11 November 2022

Our Ref: P222\_139

**Redfern North Eveleigh Precinct Renewal Project - Chief Mechanical Engineer's Building  
BCA Capability Statement for State Significant Development Application**

GROUND FLOOR PLAN
1:100

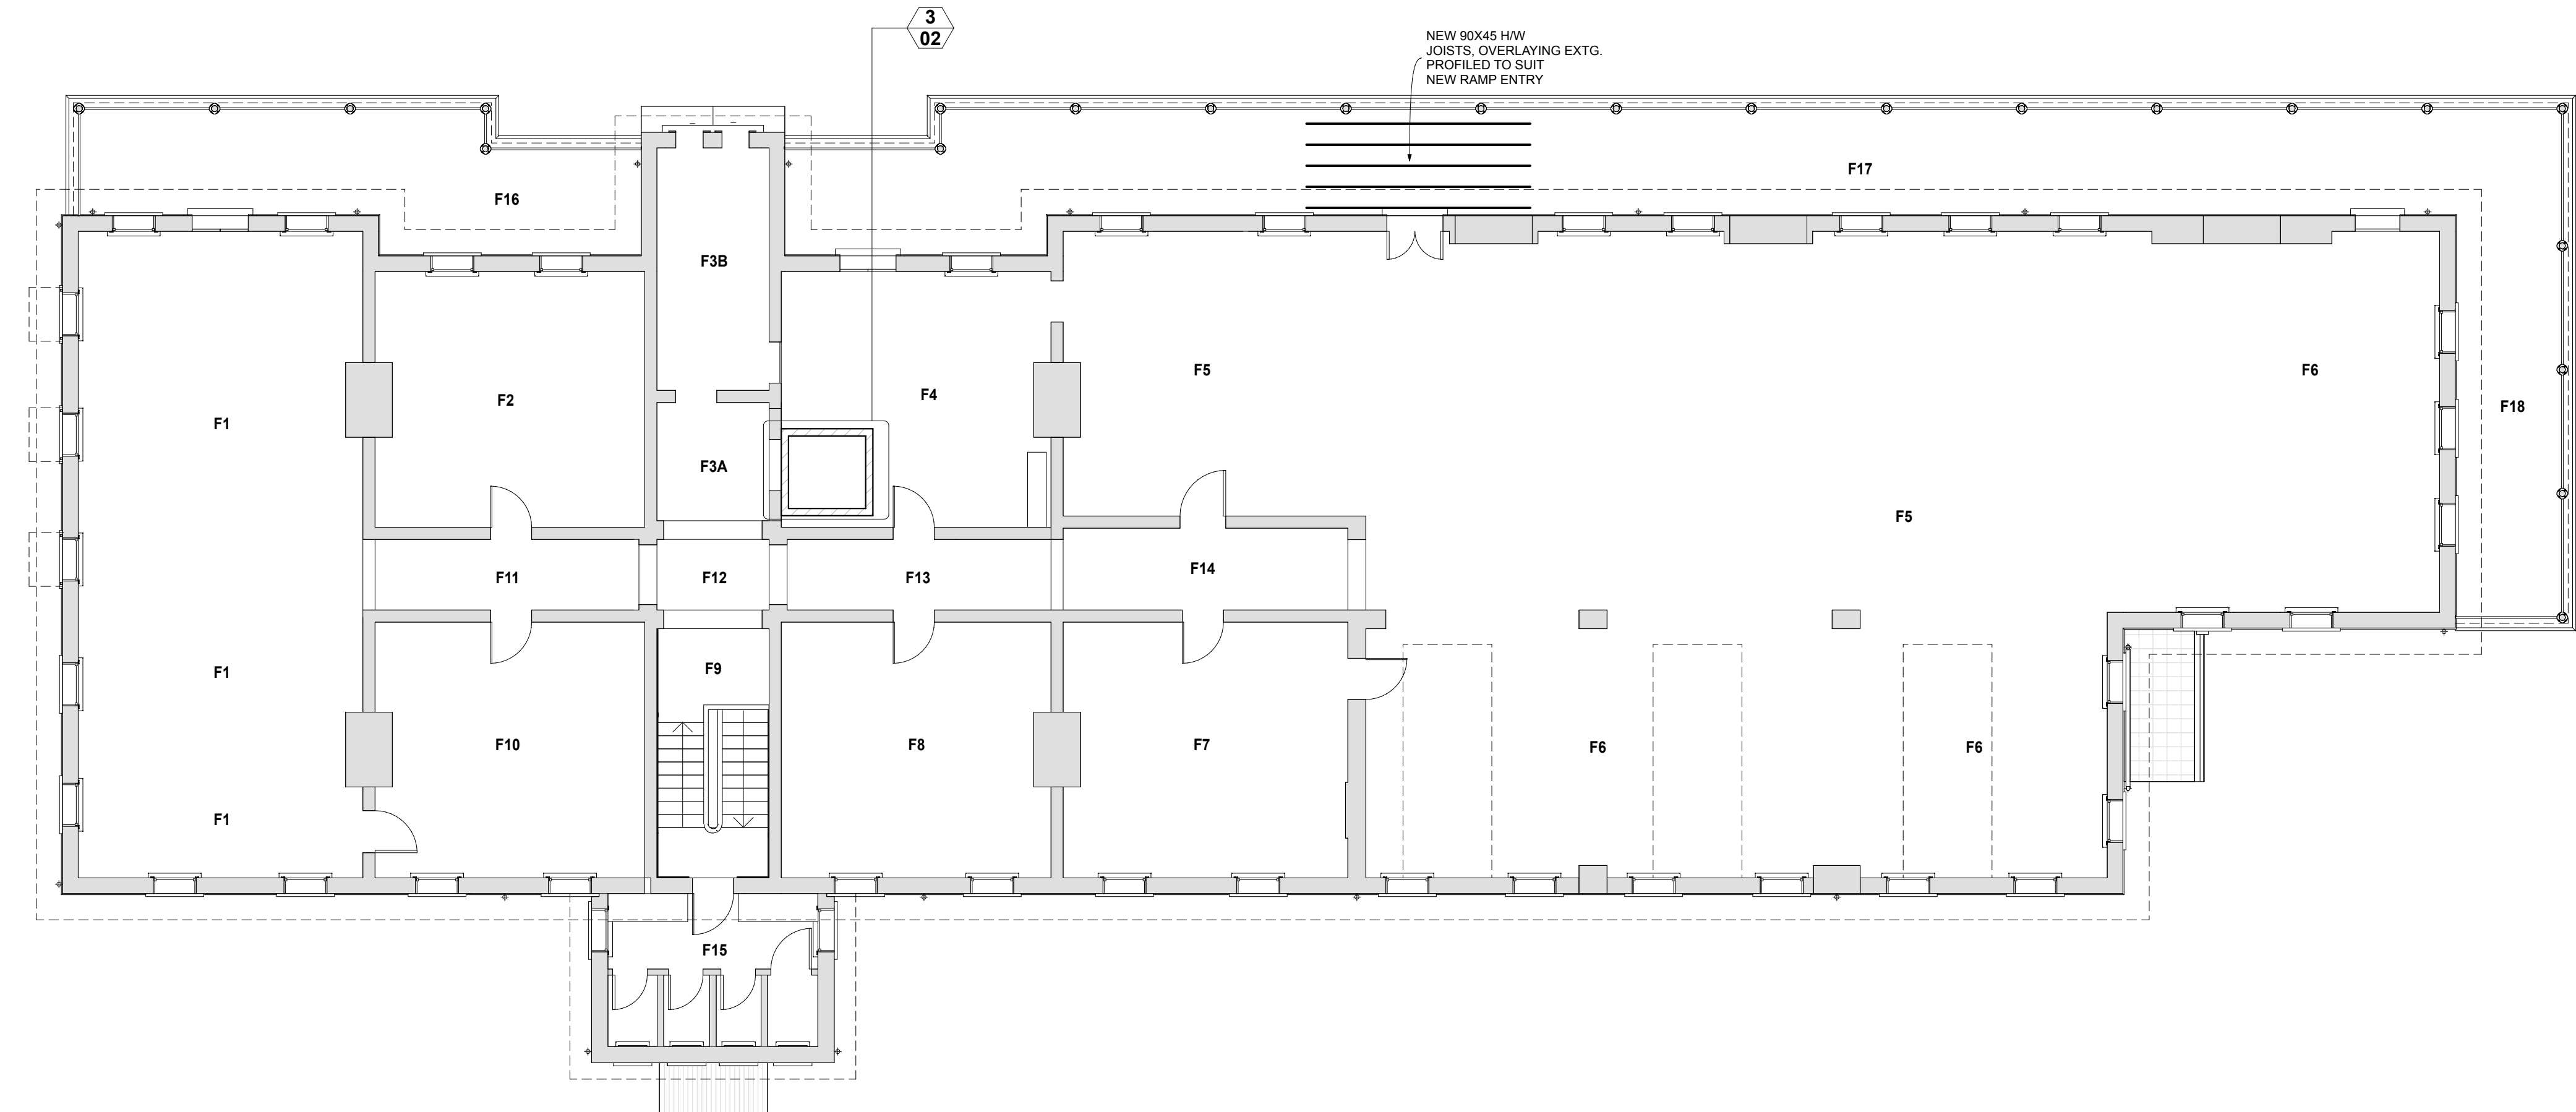
There are openings that are within 3m of the Southern boundary (G12 & F6) on the Southeast corner of the building and the Western boundary (Room G1 & F1). It is understood that these openings will be addressed with a mix of deemed to satisfy and performance-based solutions.

- (i) 910mm opening from Room G1 and G10
- (ii) 710mm opening from cubicle G18 and G20

The automated doorway serving as exits on the Ground Floor must be opened manually under a force of not more than 110N and open automatically on power failure, or activation of a fire or smoke alarm.

Two exits on the Ground floor swing in the opposite direction of egress.

A sprinkler alarm valve must be located in a secure room or enclosure which has direct egress to road or open space. The alarm valve room is located under the stairs and does not open directly to road or open space.

It is understood that a BCA Performance Solution / Fire Engineering Report will be pursued which justifies that the exit swinging in the opposite direction with the relevant Performance Requirements.

It is understood that a BCA Performance Solution / Fire Engineering Report will be pursued which justifies that the current design complies with the relevant Performance Requirements.
